September 26, 2017

**RE: Sawmill Artisan Food Market – Sector Development Plan Map Amendment (Zone Change) and a Site Development Plan for Building Permit
Project #1011292**

The purpose of this letter is to explain the modifications that have been made to the Site Development Plan for Building Permit for our project at the corner southwest corner of 6th Street NW and Haines Avenue NW. The project was approved by the Environmental Planning Commission (EPC) on August 11th, 2017.

A1 SITE PLAN FOR BUILDING PERMIT

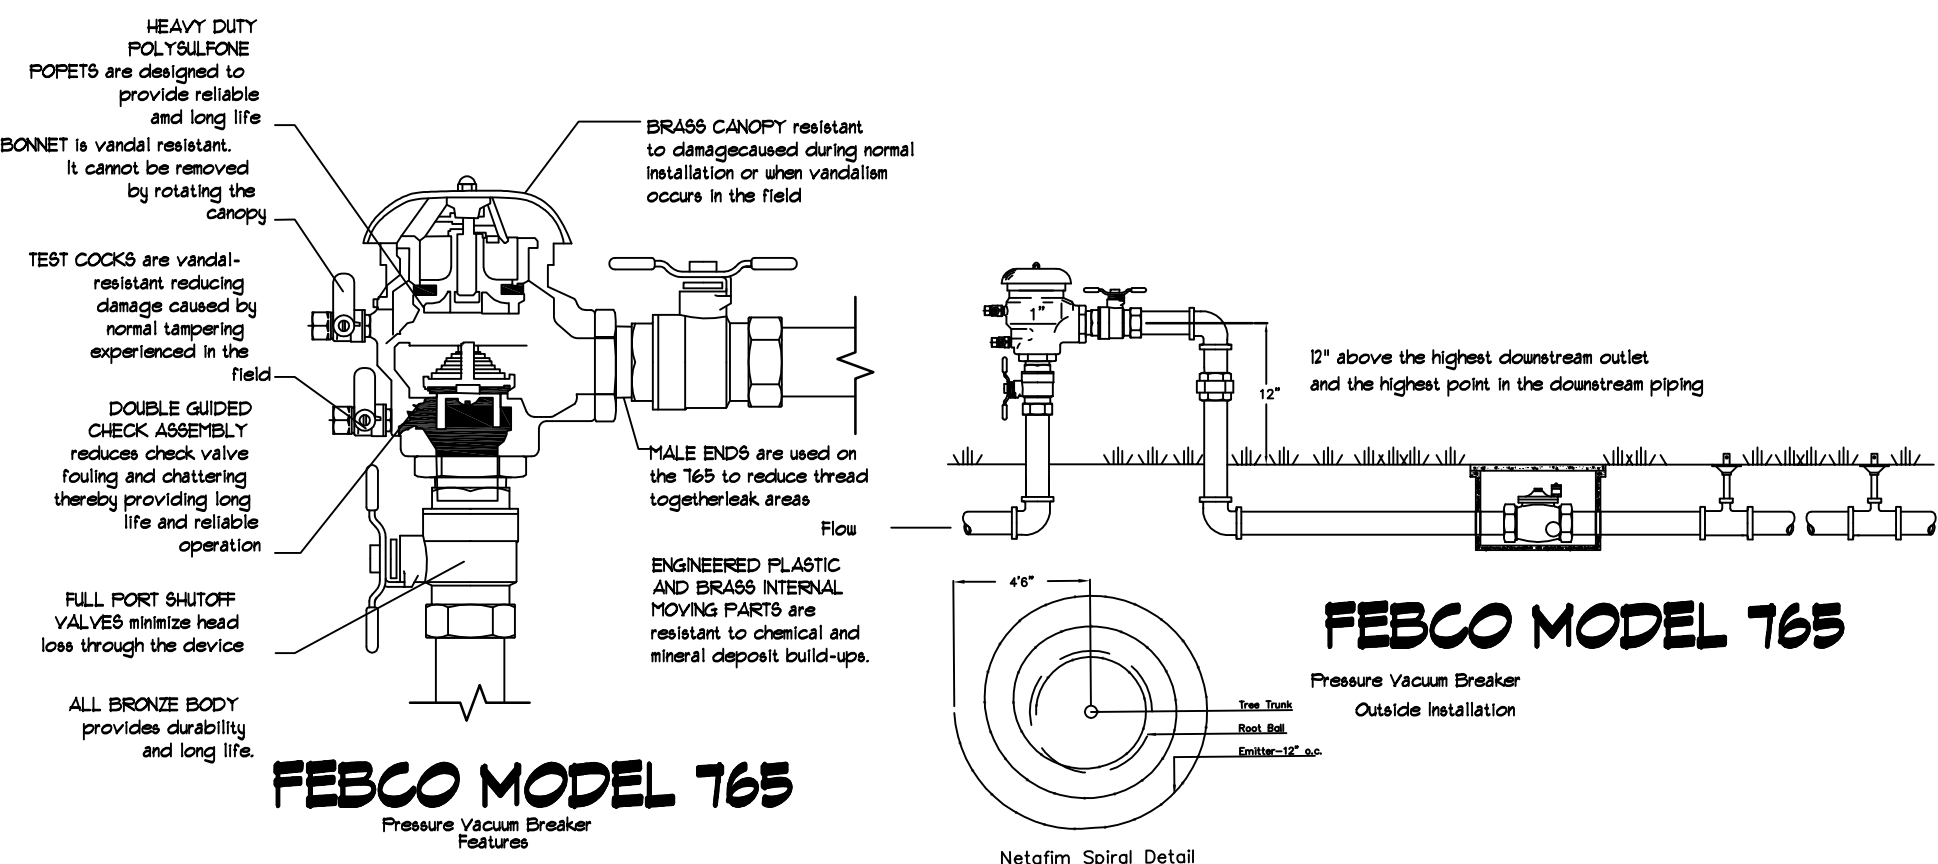
3. Per Zoning Code section 14-16-3-1 (II), pedestrian walkways shall be 6-feet wide except for stretches of 10-feet at time where a planter may reduce the walkway width including the walkways parallel to the western façade of the larger eastern building.

- Per DPM, a 6 ft. wide ADA accessible pedestrian pathway is required from the HC parking stall access aisles to the building entrances. Please clearly show this pathway and provide details.

Pedestrian walkways have been increased to 6-feet wide. We have removed proposed steps along the western side of the existing eastern building to accommodate this walkway requirement. Please see Sheet SDP-1.1.

The required 6 ft. wide Accessible Pedestrian Pathways have been shown on Sheet SDP-1.1.

BUILDING AND
STRUCTURE ELEVATIONS

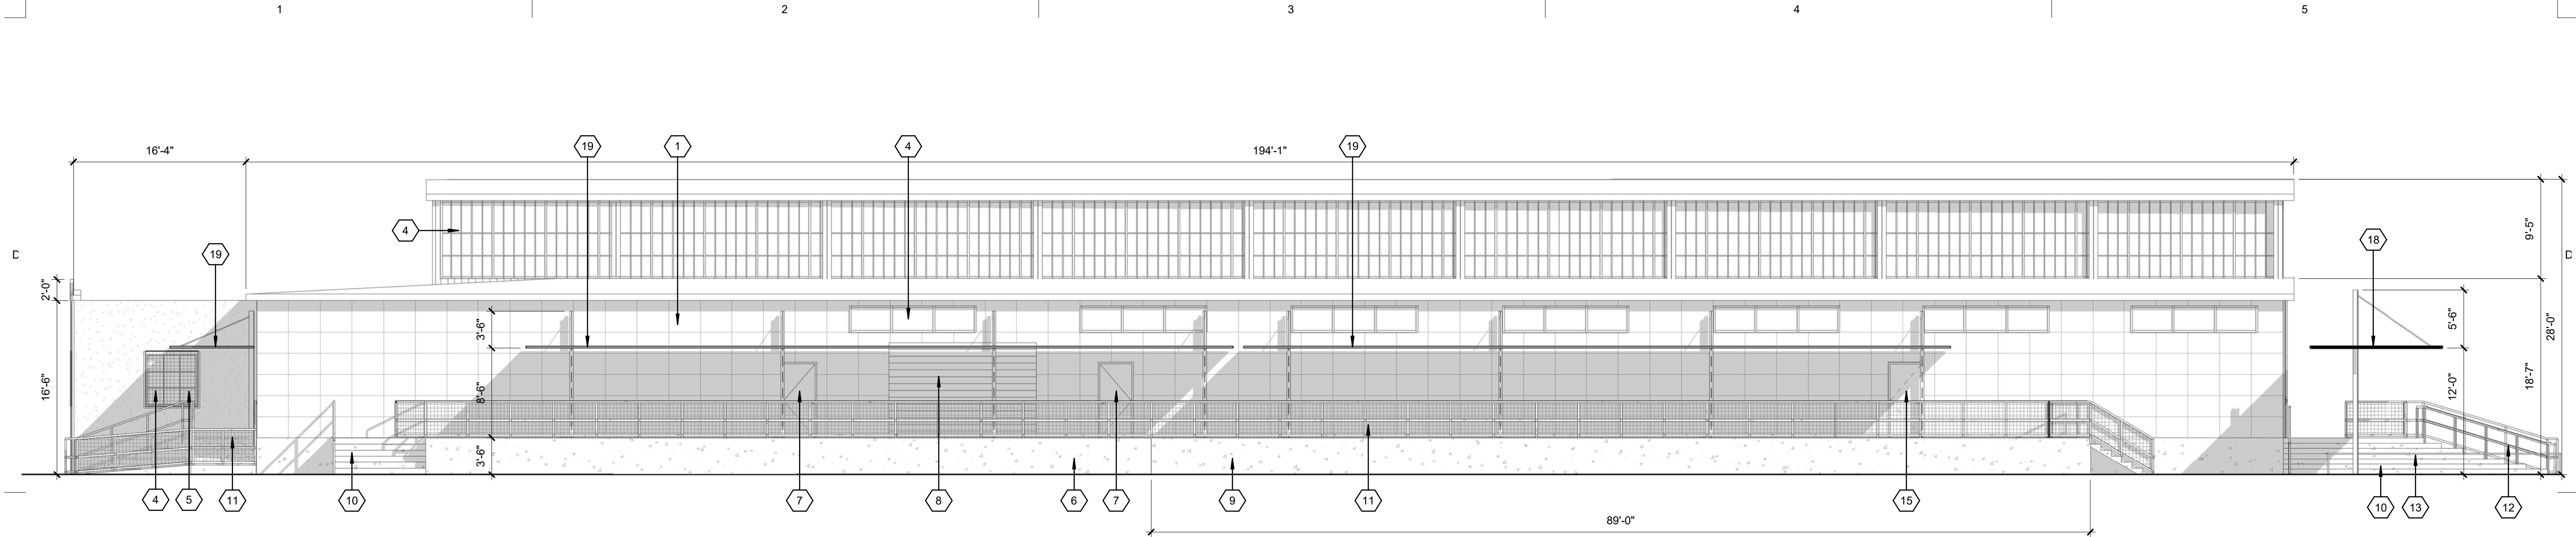
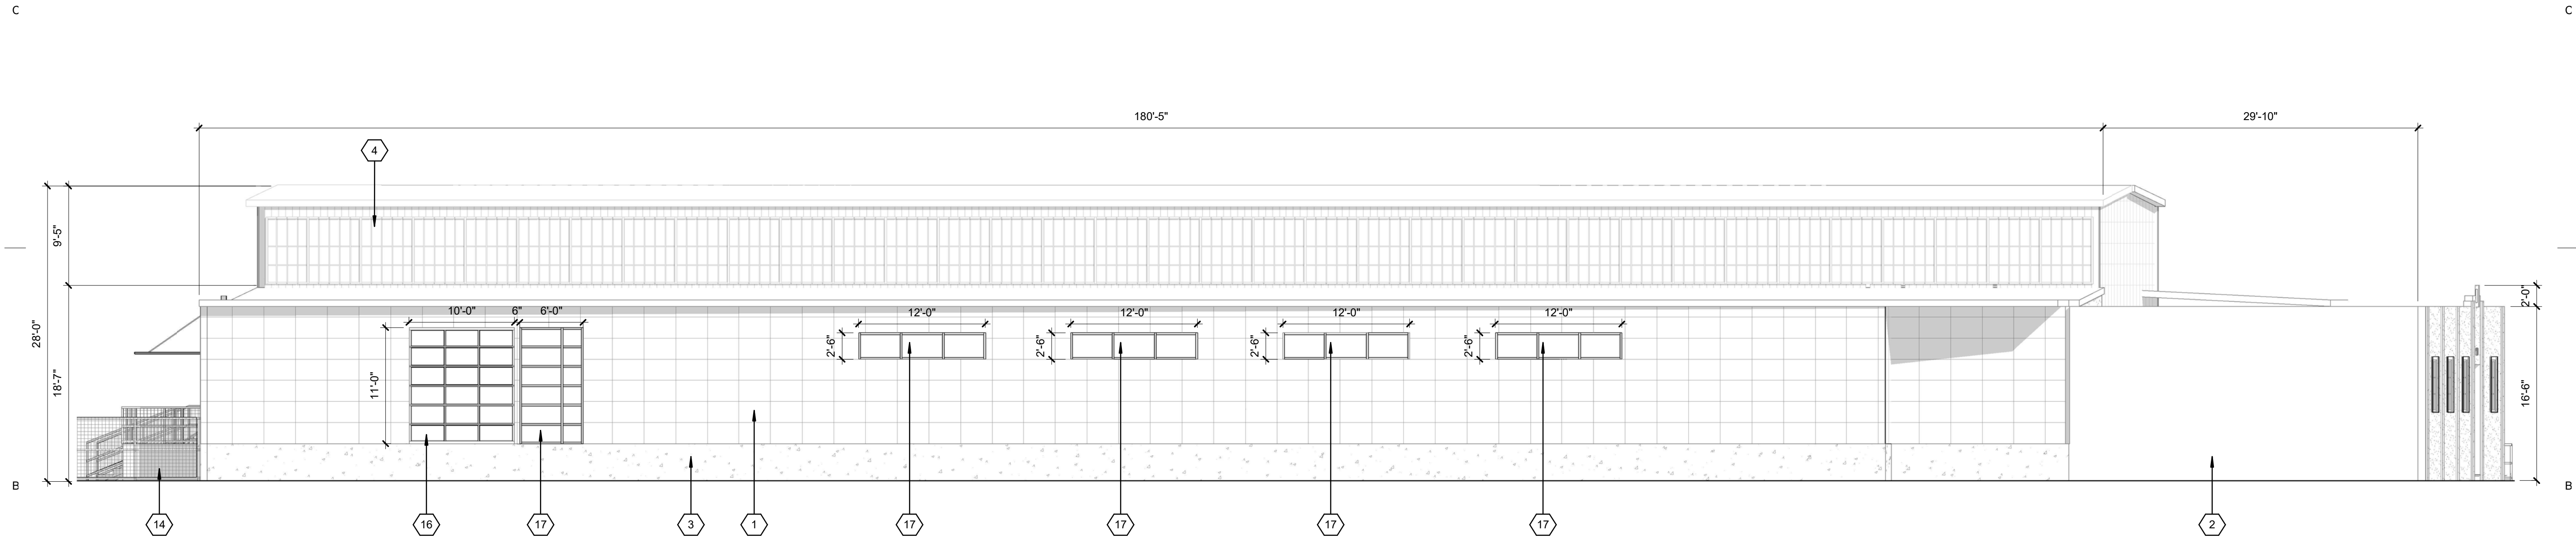
6. Under the note "SIGNAGE TO BE DETERMINED UNDER A SEPARATE PERMIT TO MEET C-2 REGULATIONS", add "Wall signs are limited to 12.5 % of the facade when a free-standing sign is on premise. A free-standing sign is limited to 75 square feet when premise is on a local street per Zoning Code 14-16-2-17 (I 0) (c) I .a."

This note has been added to Elevation sheets SDP-5.1, SDP-5.2 and SDP-5.3.

B3 SECTION - REFUSE ENCLOSURE
1/4" = 1'-0"

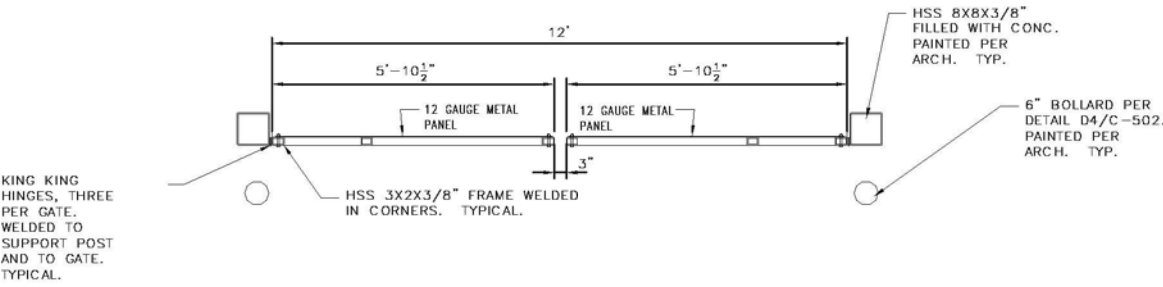
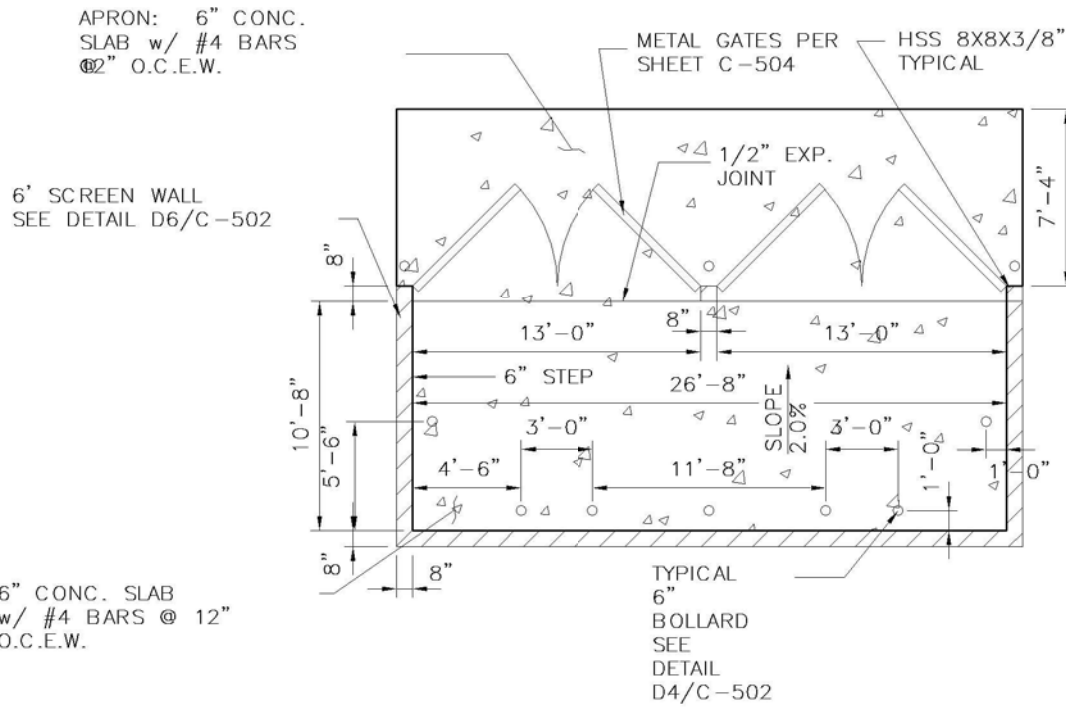
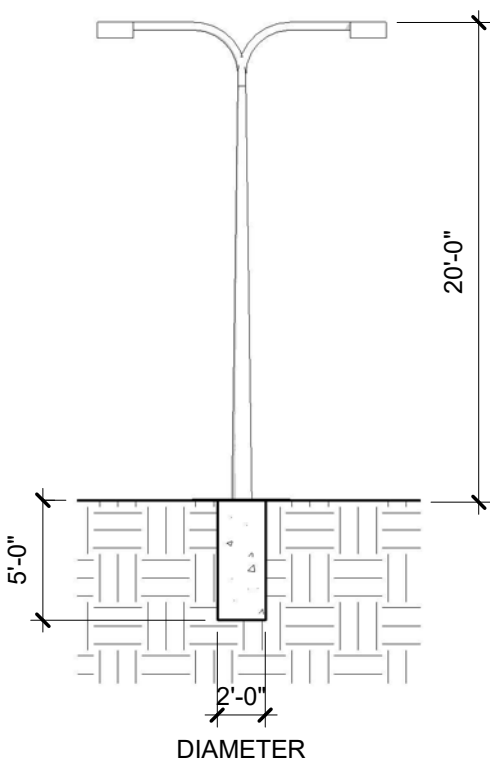
- All new/proposed refuse enclosures must be built to COA minimum requirements. The applicant shall work with Solid Waste to develop the location and pick-up requirements prior to DRB approval.

Solid Waste Management has approved the proposed refuse enclosure specifications and location. Please see attached approval.

B5 PARKING LOT LIGHT POLE DETAIL
1/8" = 1'-0"

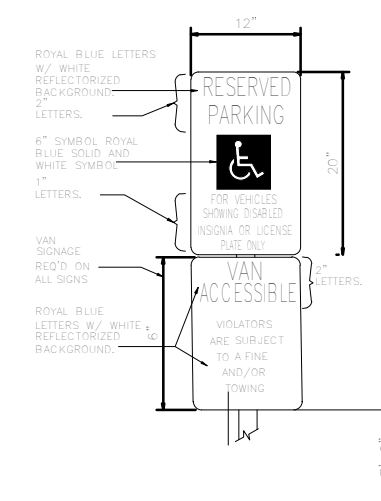
4. The Site Development Plan for Building Permit shows 30-foot parking lot LED light poles adjacent to Haines Avenue NW and 6th Street NW. For sites smaller than 5 acres, the maximum height of a light pole shall be 20-feet per Zoning Code 14-16-3-9; and lighting fixtures shall not shine directly onto the public right-of-way.

Please see Sheet Keynote number 23 on Sheet SDP-1.1 of the Site Plan for Building Permit set. We have revised the light pole height from 30-feet to 20-feet. Additionally, please see parking lot light pole detail B5 on Sheet SDP-5.4 for revised height and note indicating, "lighting fixtures shall not shine directly onto the public right-of-way".
